Application number: 2023/62/91280/e0	
What is the application for?:	Quarrying operations for the extraction of clay, shale and incidental coal and s
Address of the site or building:	Bromley Farm Quarry, Barnsley Road, Upper Cumberworth, Huddersfield, HD8 8PD
Postcode:	S36 4HG

Type of comment: An objection	
Do you wish your comments to be published on the website anonymously?	No
I write further to my original objection published online in August. Since that date, Wavin has uploaded several additional documents with updated information, however none of these address the number of issues raised by residents including confirming the route to be taken by vehicles transporting the material, thus failing to allay the concerns of those living on, or walking, cycling or riding horses down Carr Hill Road. Further, Wavin has had ample opportunity to engage in open dialogue with the community. This would have been an opportunity for them to explain the application, discuss exactly what they intend to do, for how long and how they intend to mitigate the impact to residents, as well as making clear any benefits to the community. They could have attended one of the many meetings held in Upper Cu

Map 10

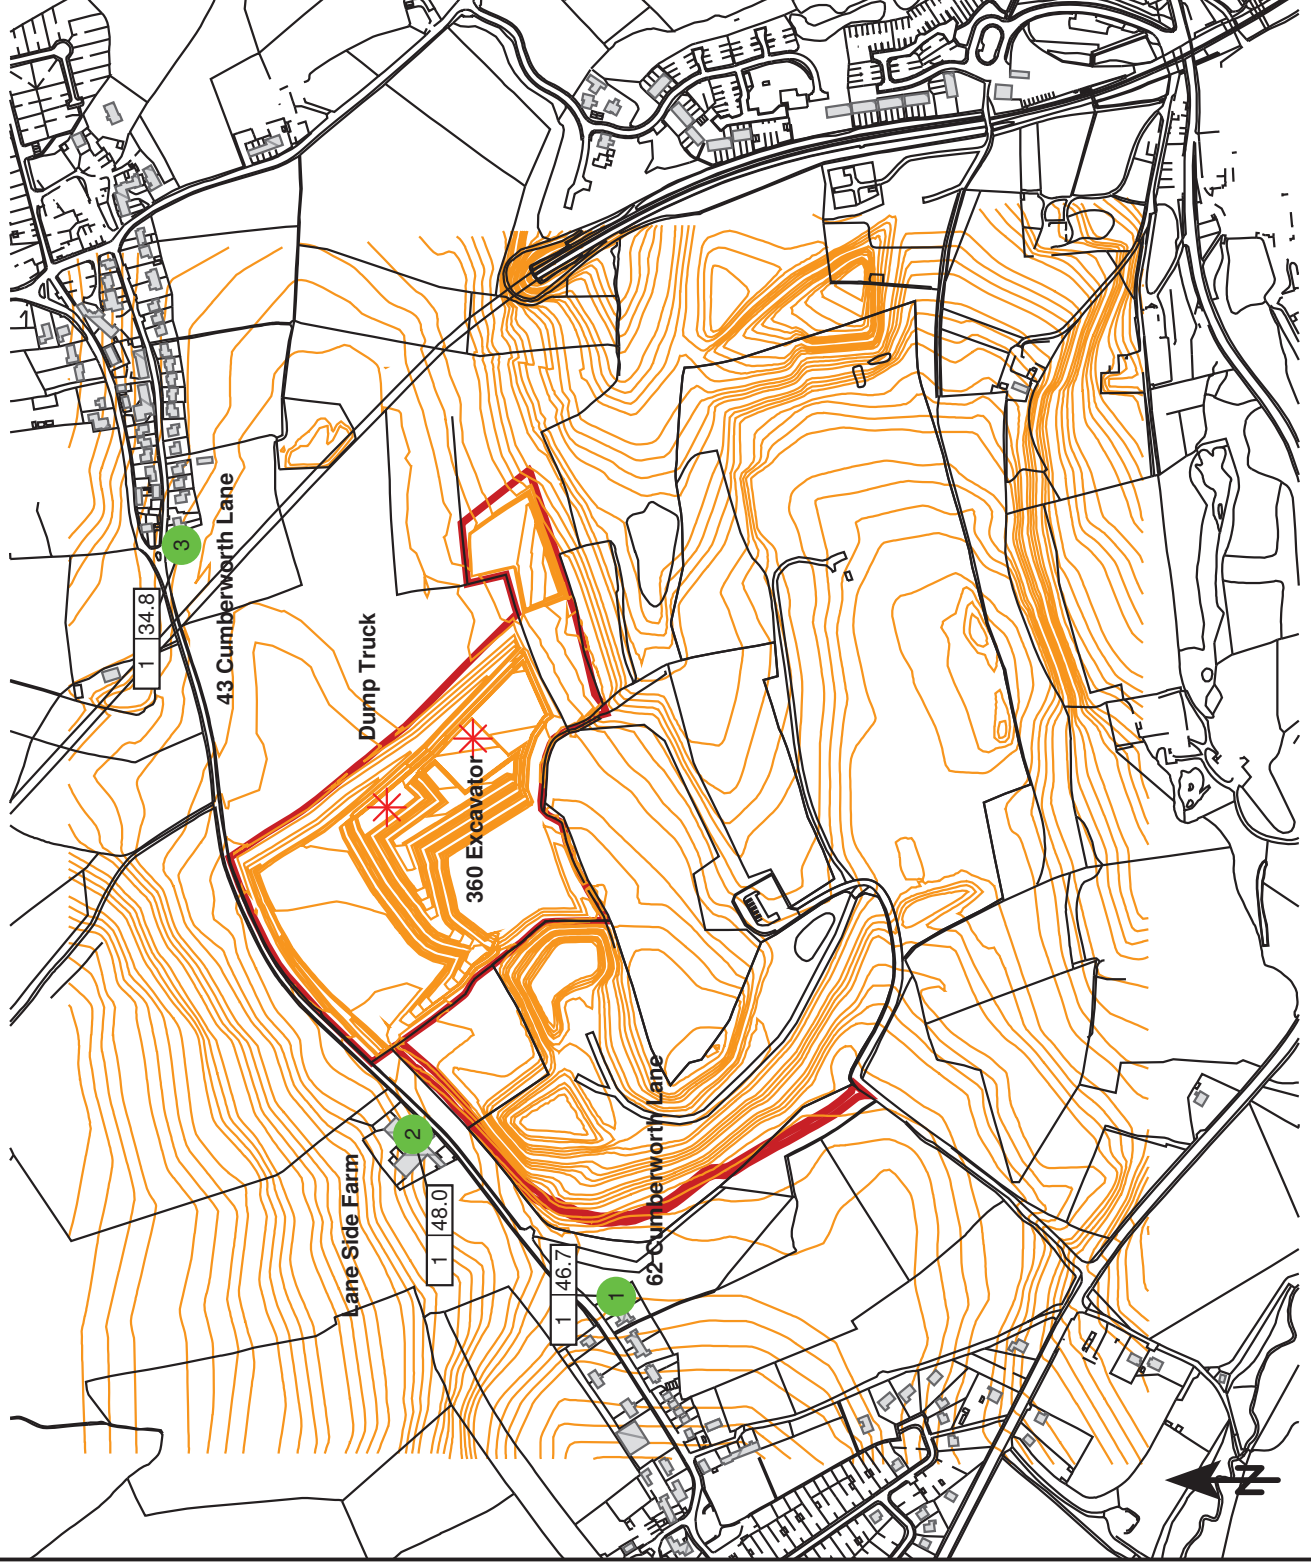
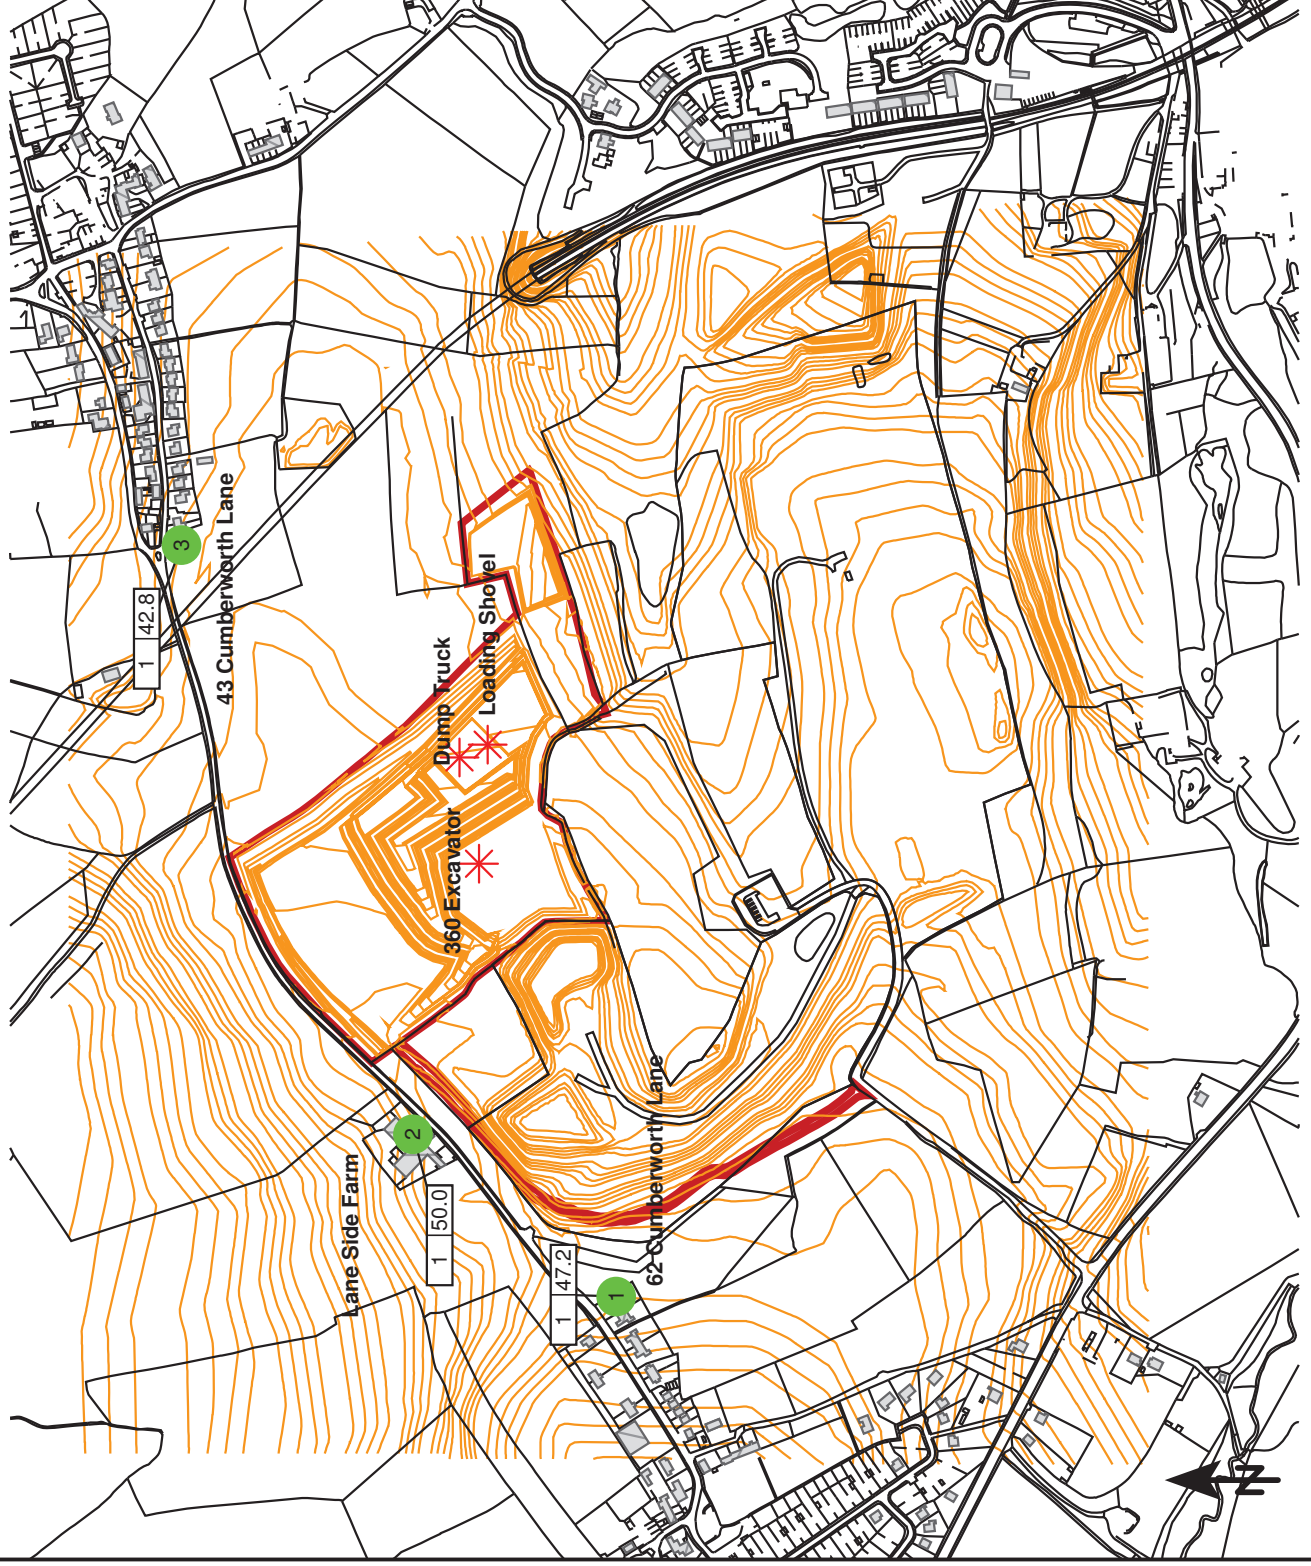
The updated noise document includes maps which show noise assessment and decibel level over the area. However, several of these maps (including maps 10 and 12) fail to show the full extent of how far the noise will travel, and cut off still in the 35-40dB region, even though the 30-35dB area will extend considerably beyond the edge of the map, meaning more residents will be affected than is shown. With regard to the transportation and additional road noise, a considerable amount of research has been done around how road surfaces can reduce the noise of vehicles. I would heavily implore the council (and Highways England) to consider factoring this into their decision and investigating whether (if approved) some of the noise can be mitigated by resurfacing the roads Wavin intend to take with a low-noise road surface and ensuring that potholes, manholes and other dips in the road are brought up to road level to reduce banging noises.
